Our DTS Ref: 26322  
Your Ref: 6/2019/1788/COND

Re: FORMER SHREDDED WHEAT FACTORY, BRIDGE ROAD, WELWYN GARDEN CITY,  
HERTFORDSHIRE, AL8 6UN

Thank you for consulting Thames Water for the discharge of matters relating to SURFACE WATER. Thames Water are unable to support the discharge of this condition for the reasons outlined below.

PROPOSED DRAINAGE LAYOUT (PHASE 1)

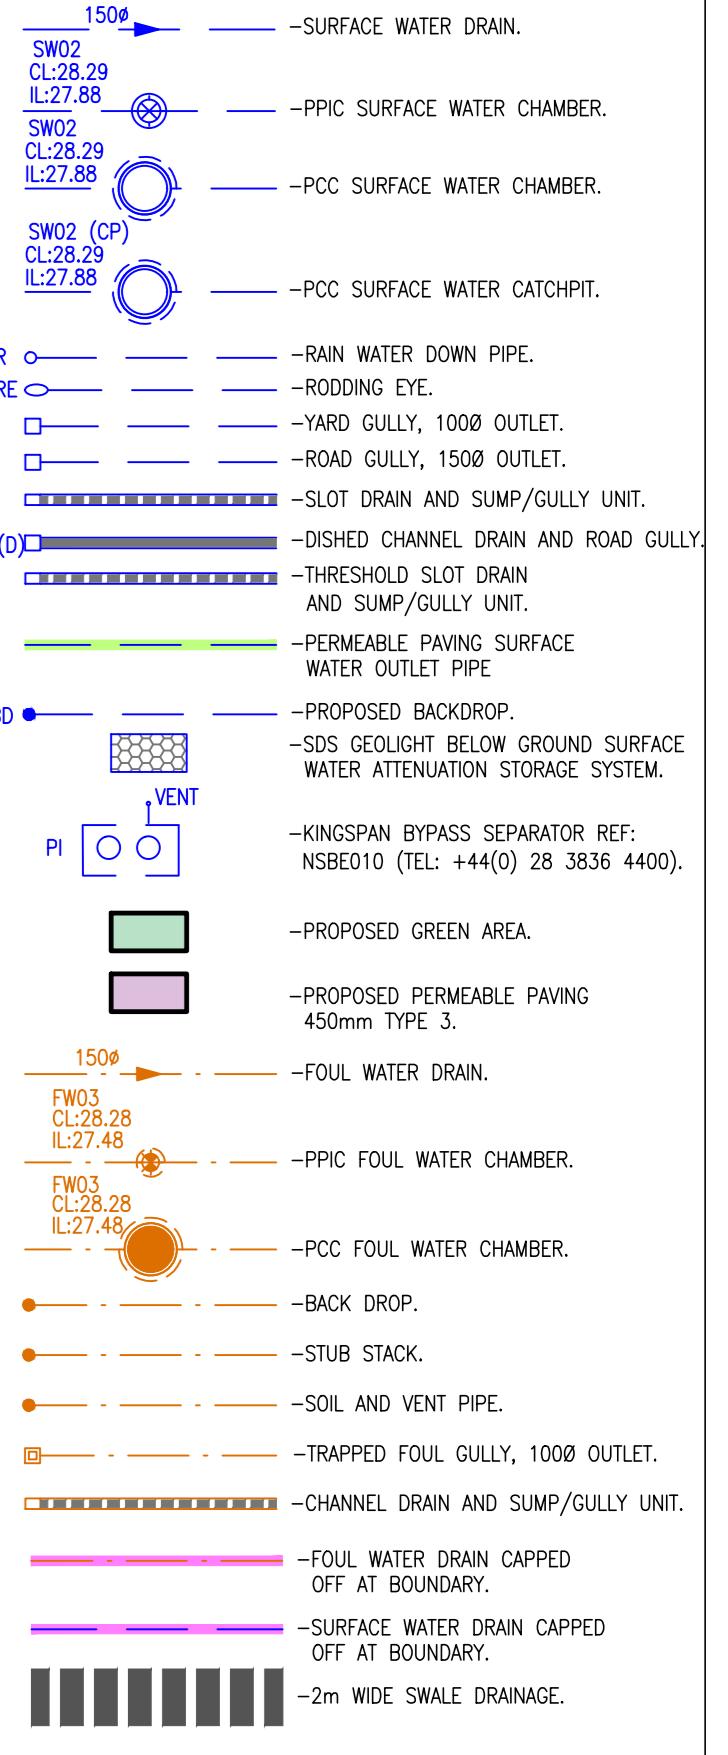
The strategy lacks detail only calculations which don't articulate the intended flows etc. Give a brief description of volumes, discharge rates say 1:1, 1:10, 1:30 and 1:100. Also show and give capacity of any attenuation.
